AW-159-13 – 78 Barrack Lane – OBJECTION – 19-8-2013

OBJECTION – AW/159/13 – erection of new garage 78 Barrack Lane within the Barrack Lane Area of Special Character

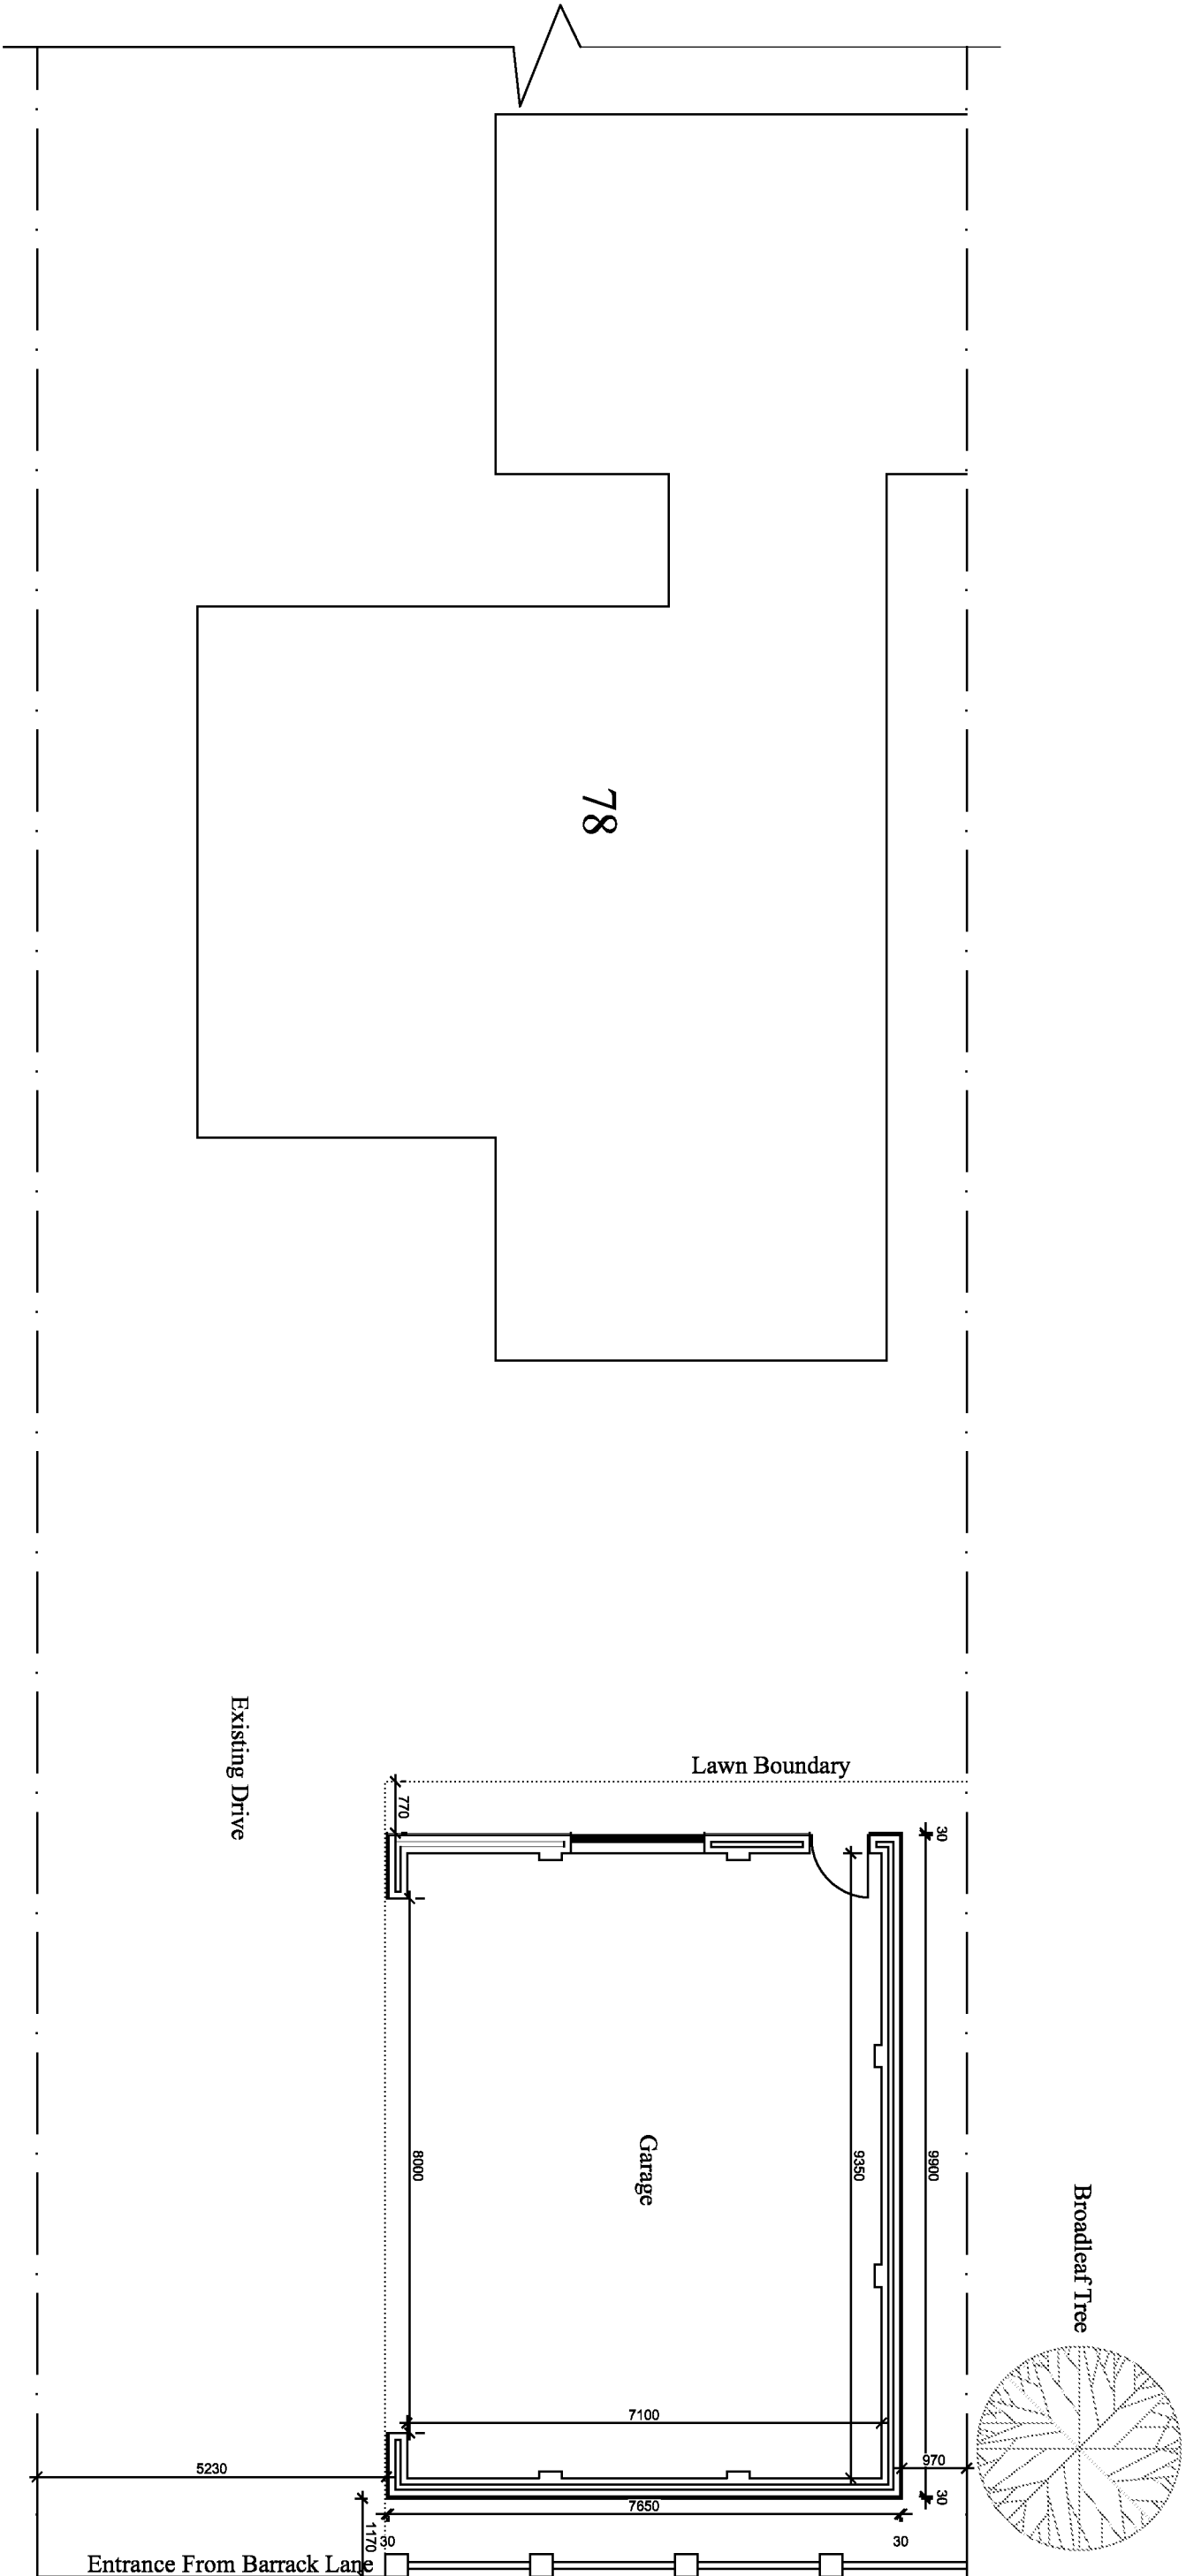
We have studied this application, which is within the Barrack Lane Area of Special Character and consider that the proposed development of a double garage hard up to the eastern fence, just 1m from the western Barrack Lane verge fails, on any count, to make a '*positive contribution to the special character of the area*' and is, therefore, in conflict with Policy Areal of the Local Plan.

What is so pronounced and obvious is that there is no need to develop hard up to the roadway for there is plenty of space for a garage elsewhere, given professional advice, design and layout. In reality, this is the very last place to site a garage for this house.

6. *'Allows for the safe movement of pedestrians and vehicles, giving priority to pedestrians'*. There is no footpath on this side of Barrack Lane and the garage will block all vision to the north when exiting this site, creating a potentially highly dangerous situation. Exiting from Fernhurst Gardens right now is a most dangerous operation for cars coming from No.78 and others cannot be seen. This proposal would exacerbate the traffic situation at this point.

At Section 7 on the planning application form it is accepted that there are trees which are within falling distance of the proposed development. **Yet, there is no Tree Survey as required by BS5837:2012. We ask that one be submitted and that the District Arboriculturalist be asked to inspect the site, giving particular attention to the trees, hard up to the boundary where the garage is to be located, in 76 Barrack Lane.**

If the trees are NOT subject to such protection then, in any event, they are not in the ownership of the applicant and the owner at No. 76 wishes to retain them. All the tree feeder roots are in the top 600mm (2 feet) of the soil and will spread across No.78's front garden and the verge. The dig footings along that boundary would destroy 180 degrees of the roots which secure water, air and nutrition to feed the tree. Damaging those would either kill or most seriously damage the trees and must not be allowed to happen. The strict conditions of BS5837:2012 must be applied, in CHECAA's view. TPO'd or not, the trees in No. 76 Barrack Lane are of very significant public amenity value and must be retained, unharmed.

Proposed Front Elevation - Street View

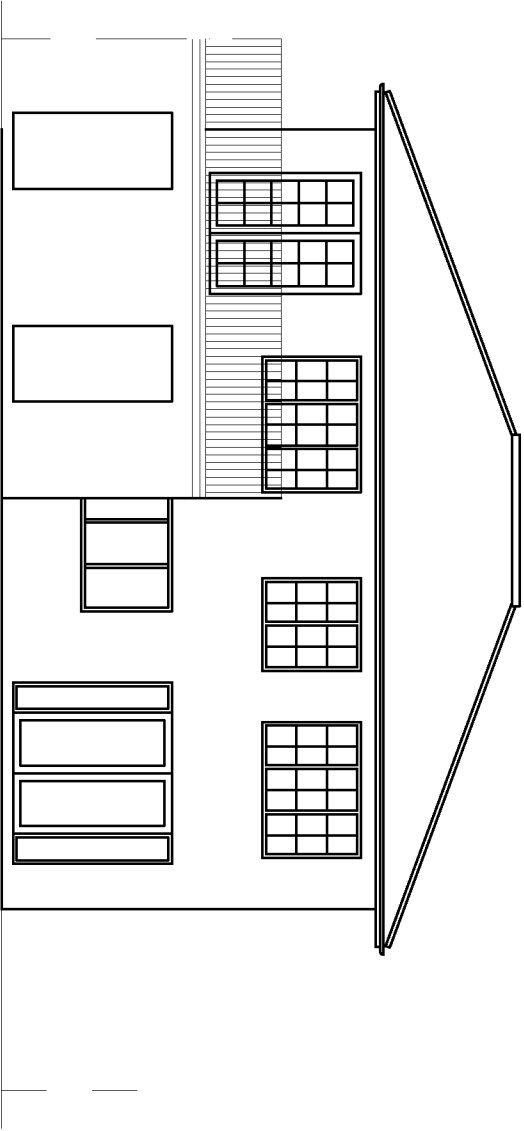
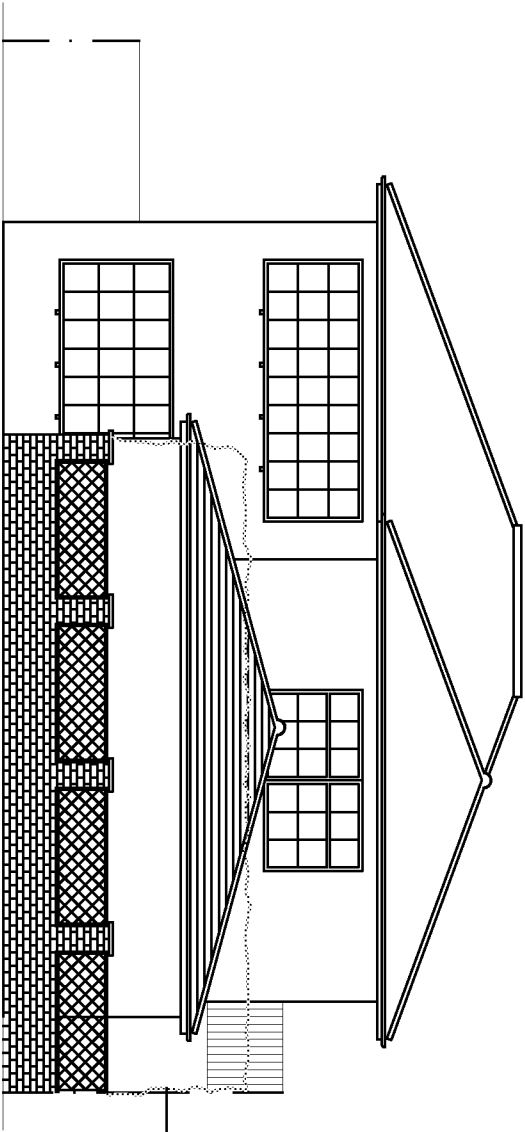
5. *'Retains significant open areas which, in their own right, make a material contribution to the local environment'*. The wide, open frontages in this part of Barrack Lane are an important part of its established character and must not be lost to shoddy, ill conceived development as is this garage project.
